**DELEGATED ADVERTISEMENT DECISION**

24399/APP/2024/1166      37 VICTORIA ROAD RUISLIP

The application proposes the installation of 1no. externally illuminated fascia sign and 1no. projecting sign.

0	1	2	4
Drawing No.	A - 001		
Revision No.	01		
Scale at A3	1:100		
Date	08-09-2025

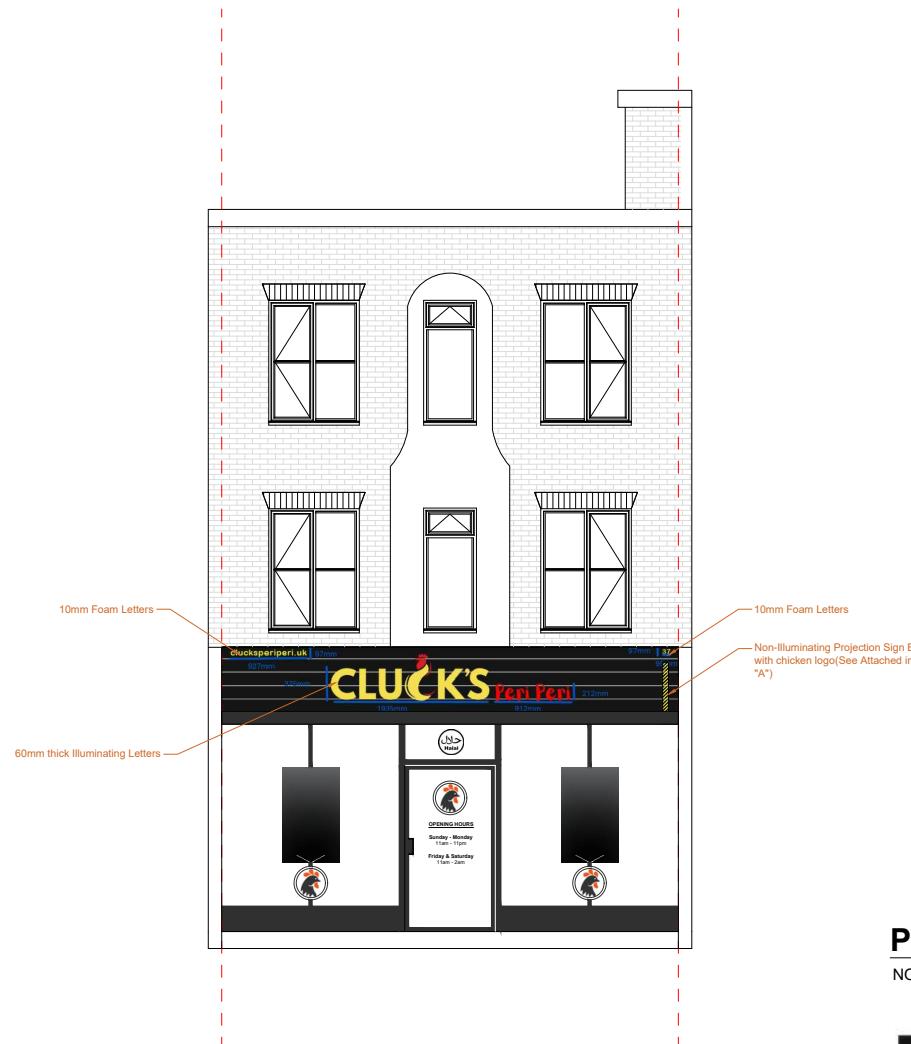
In terms of residential amenity, it was originally proposed that the projecting sign would be illuminated, as well as the fascia sign. The proposal has been amended during the application to omit the illumination of the projecting sign, only the fascia sign is proposed to be illuminated. Furthermore, should consent be granted, conditions would be imposed to restrict the intensity of illumination to below 300 cd/sqm (Condition 3 - Intensity of Illumination) and will ensure that the illumination of the sign is a fixed constant light (Condition 5 - Type of Illumination). Furthermore, Condition 4 (Hours of Illumination) will limit the hours of illumination to be in line with the hours of opening, i.e. the sign shall not be illuminated between 11pm and 9am (Monday to Saturday) and 10pm and 10am (Sundays, Public or Bank Holidays).

The proposed signs would be set back from the highway comprised within a parade of retail and commercial units with many similar signage schemes in the locality. The fascia sign would comprise front-lit LED lights with a maximum illuminance of 300 cd/m<sup>2</sup>. The projecting sign would not be illuminated. The level of illuminance for the fascia sign is considered to be appropriate for a mixed use urban area whereby there are residential properties in the immediate vicinity, in this case directly above the shop unit. In addition, the illumination would be restricted to hours of opening, i.e. the sign will not be illuminated between 11pm and 9am (Monday to Saturday) and 10pm and 10am (Sundays, Public or Bank Holidays). Overall, it is considered that the proposed signage scheme is appropriate for the area and will not cause any significant harm in terms of visual or residential amenity.

A - 001 Rev 01

The intensity of illumination of the advertisement(s) shall not exceed 300 cd/m<sup>2</sup>.

The sign shall not be illuminated between the following hours:

11pm and 9am (Monday to Saturday)

10pm and 10am (Sundays, Public or Bank Holidays)
